Our Ref: AW/70/19/T
Your Ref:

Town & Country Planning Act 1990 (as amended)
Town & Country Planning (Tree Preservation) (England) Regulations 2012
Application for Works to Tree(s) on trees subject to a Tree Preservation Order (TPO)

Development Works to trees subject to a tree preservation order.

Location Holly Lodge 3 Barrack Lane Aldwick

LOCATION PLAN.

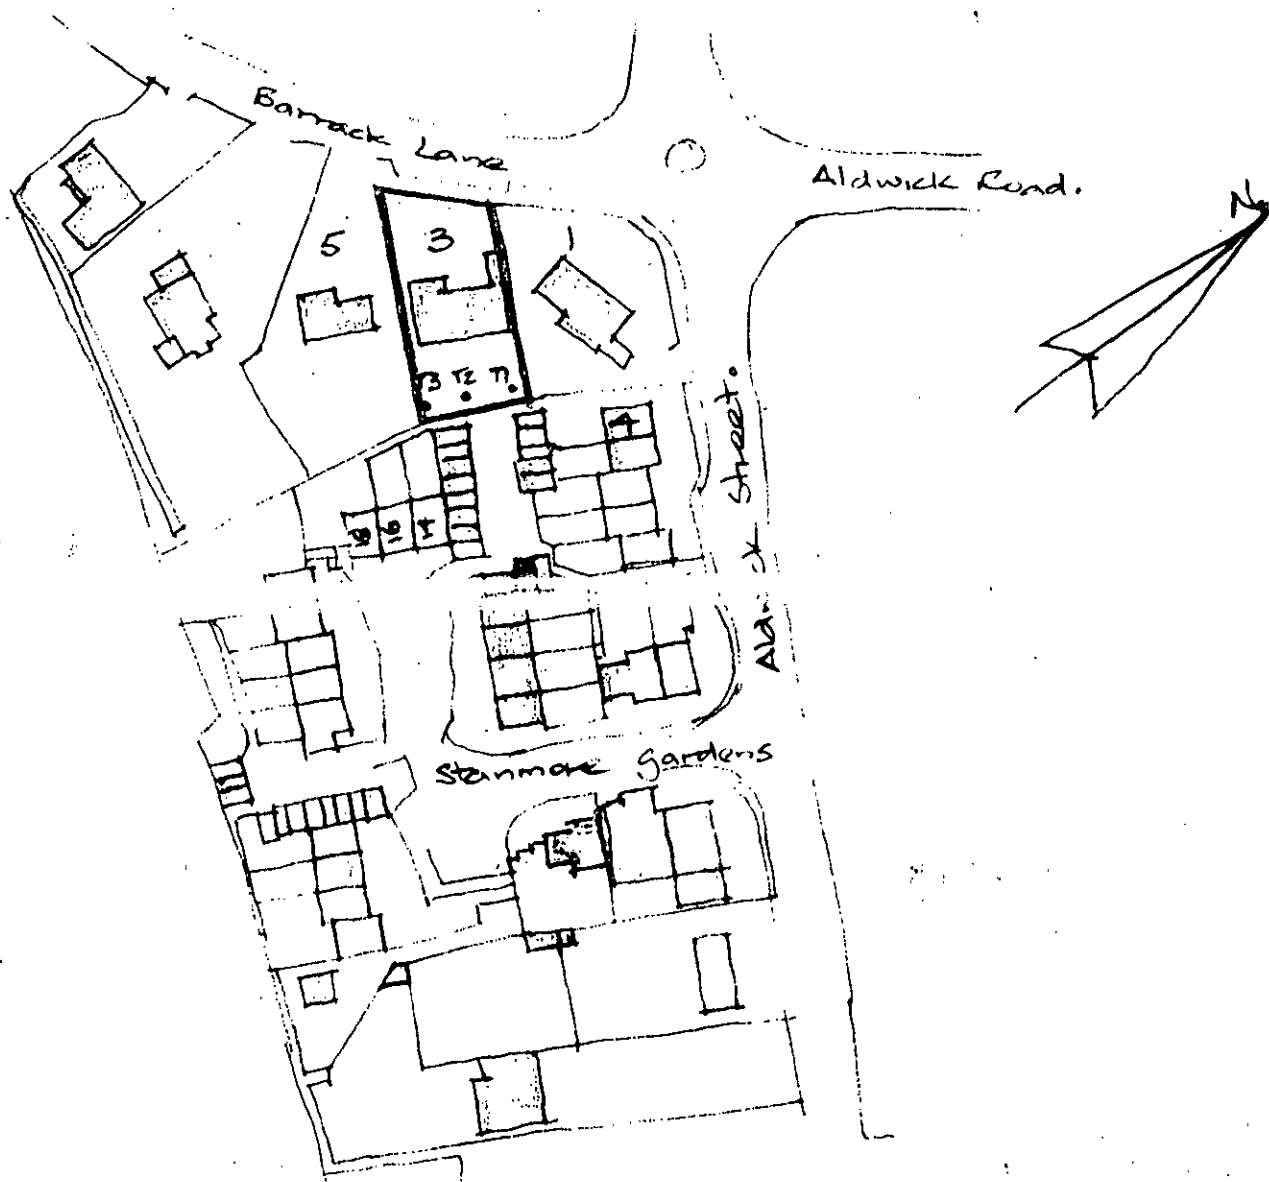
Please confirm in metres how much to be removed from 2 No Holm Oak trees for the Crown lift and Crown reduction.

Please confirm in metres how much to be removed from 1 No. Sycamore tree for the Crown reduction.

Please confirm if split bough is to be reduced or removed. If reduced, please confirm in metres how much is to be removed.
